**UNIVERSITY OF SYDNEY CENTRE FOR OBESITY, DIABETES AND CARDIOVASCULAR DISEASE
PROJECT (MP 09_0051) – RESPONSE TO SUBMISSIONS**

University of Sydney Centre for Obesity, Diabetes and Cardiovascular Disease Project (MP 09_0051)
Response to Submissions Table

**Major Project Application No. 09_0051
University of Sydney Centre for Obesity, Diabetes, and
Cardiovascular Disease (CODCD)
Response to Comments from City of Sydney**

LEVEL B2 BASEMENT PLAN

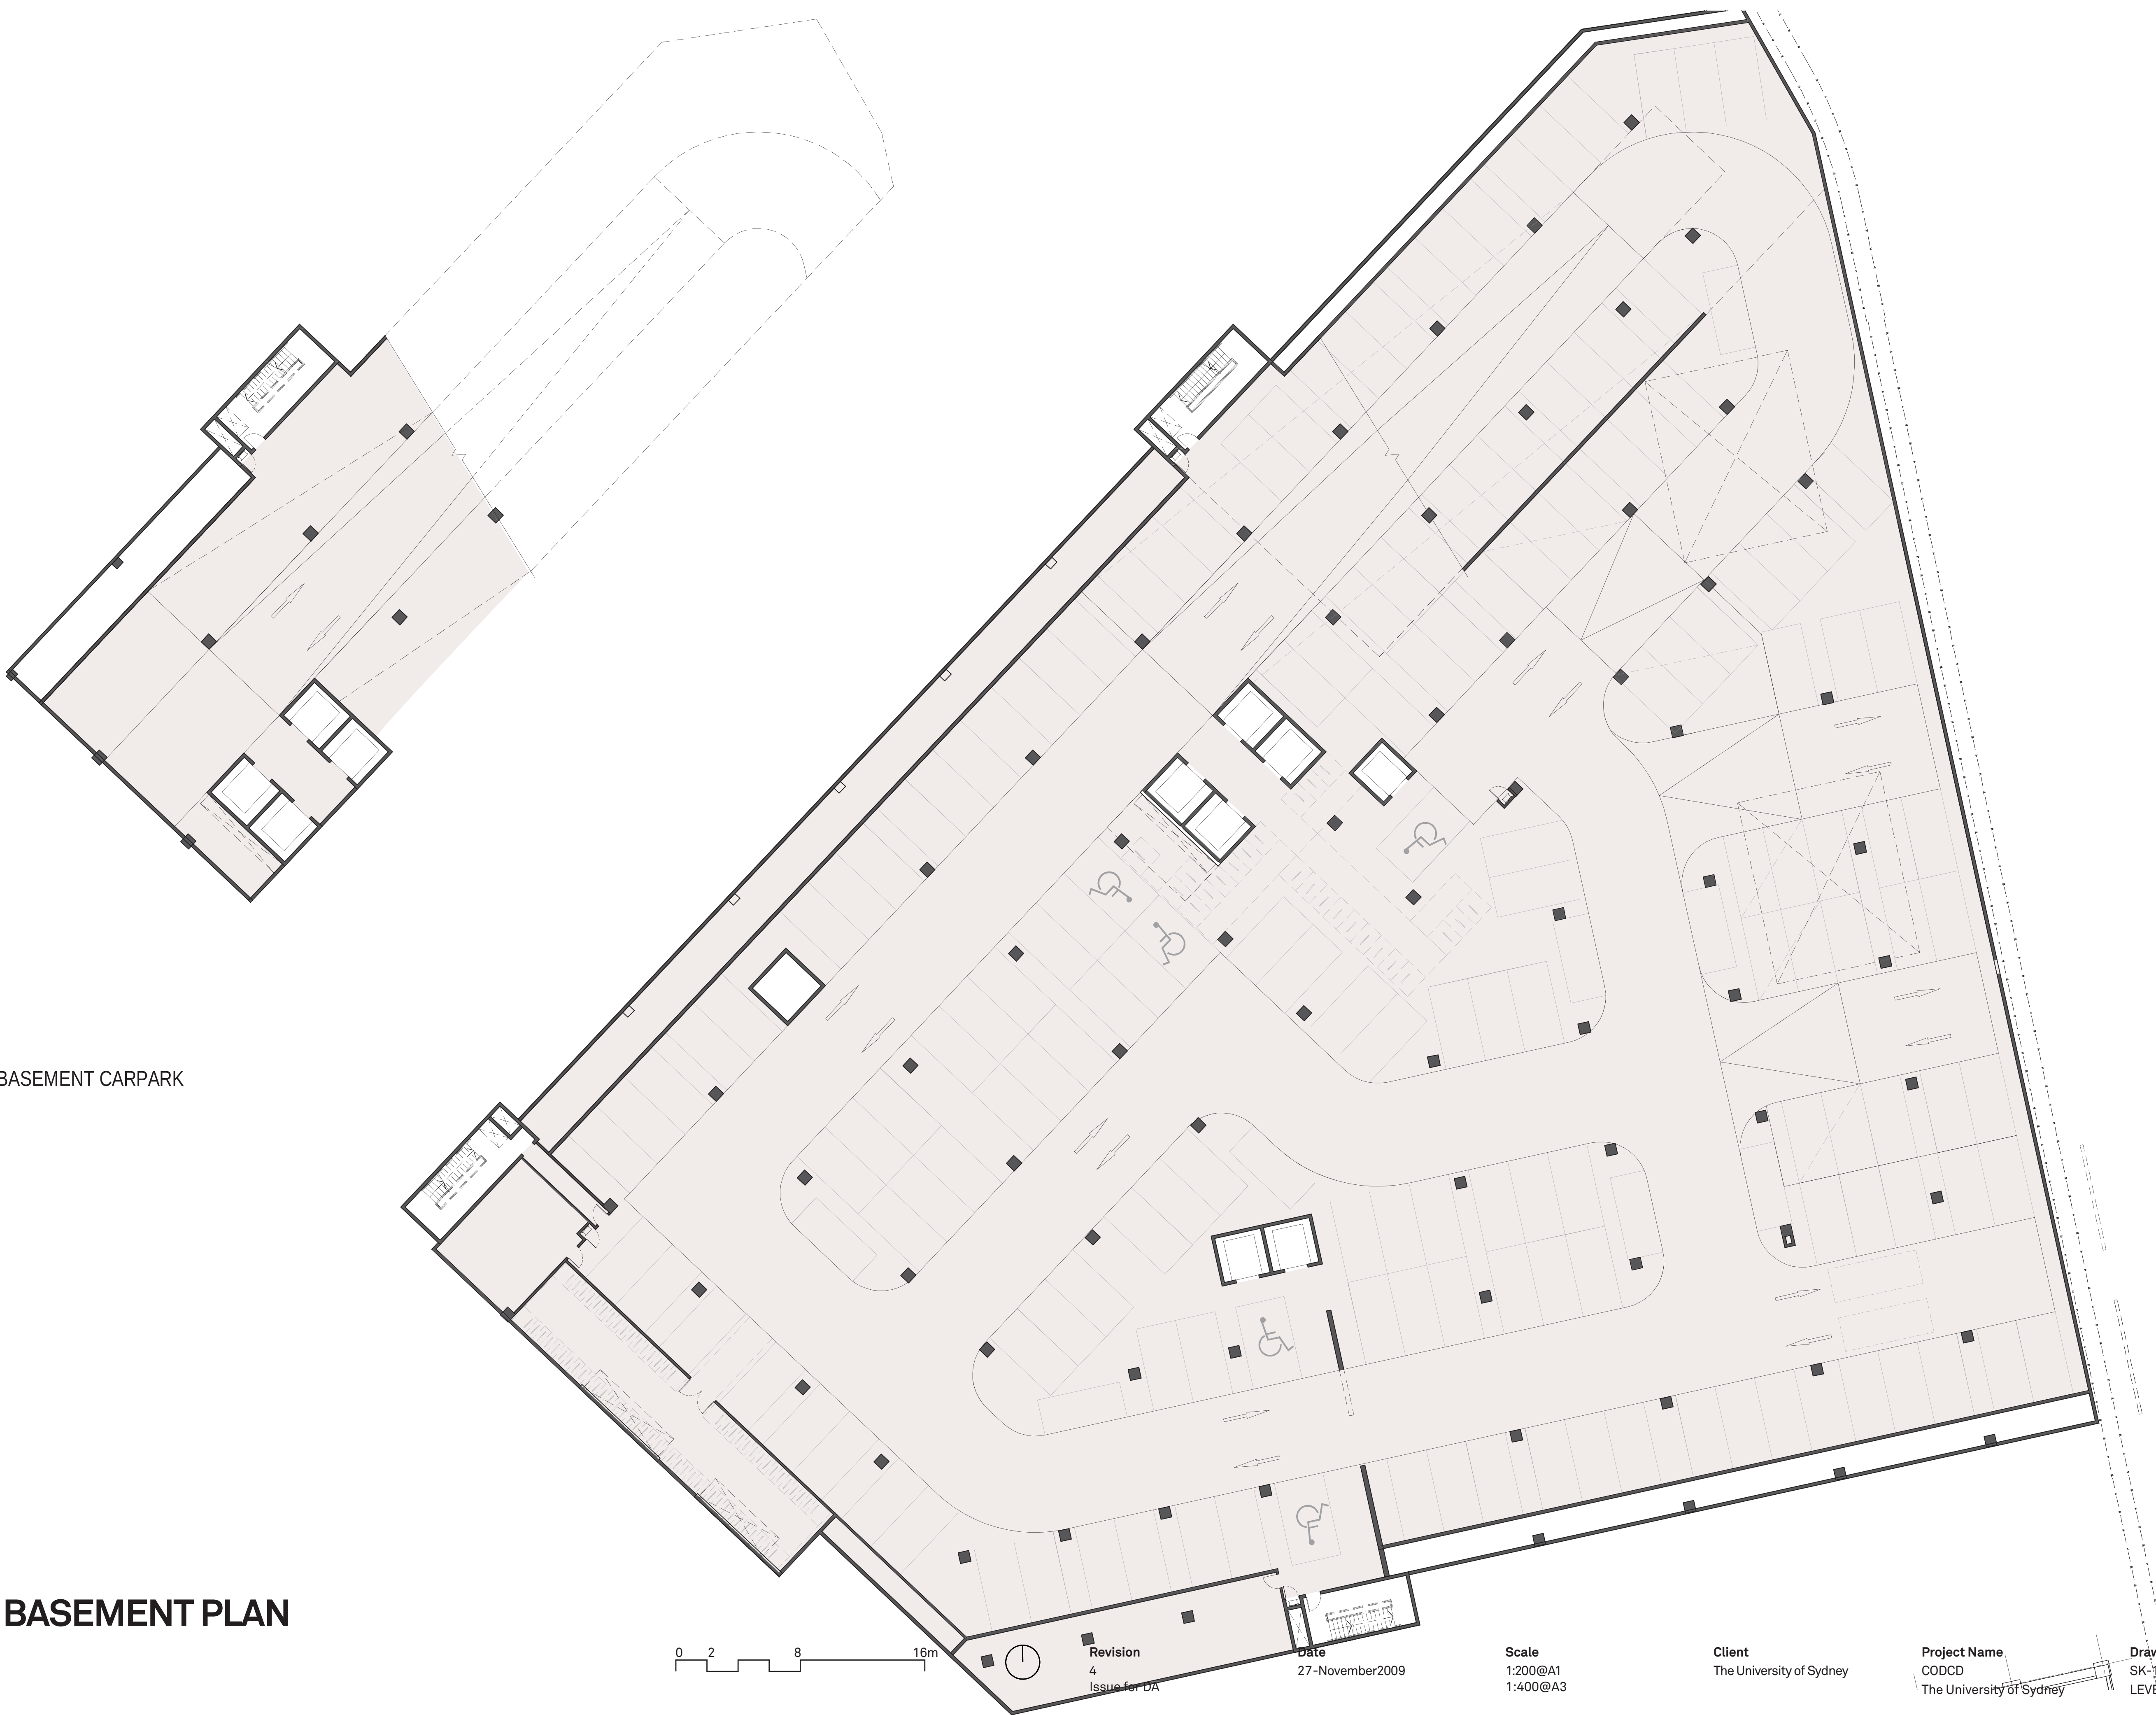
<i>Disabled Parking</i>	SSWAHS comments that there is no indication of disabled parking provision within the basement area.	The University notes that disabled parking provision is indicated on the Level B2 Basement floor plans, and that EA includes a commitment to providing parking in accordance with relevant standards, including the provision of disabled parking (Commitment 1.3.16).	-
<i>Bicycle Infrastructure and Facilities</i>	SSWAHS comments that it is critical that the proposed cycle path connecting the Ross Street exist of the University to John Hopkins Drive and	The project has been designed in a manner that integrates with existing and planned bicycle networks within and adjacent the University (refer to response to Sydney City Council regarding bicycle networks for	Additional plan showing available bicycle access
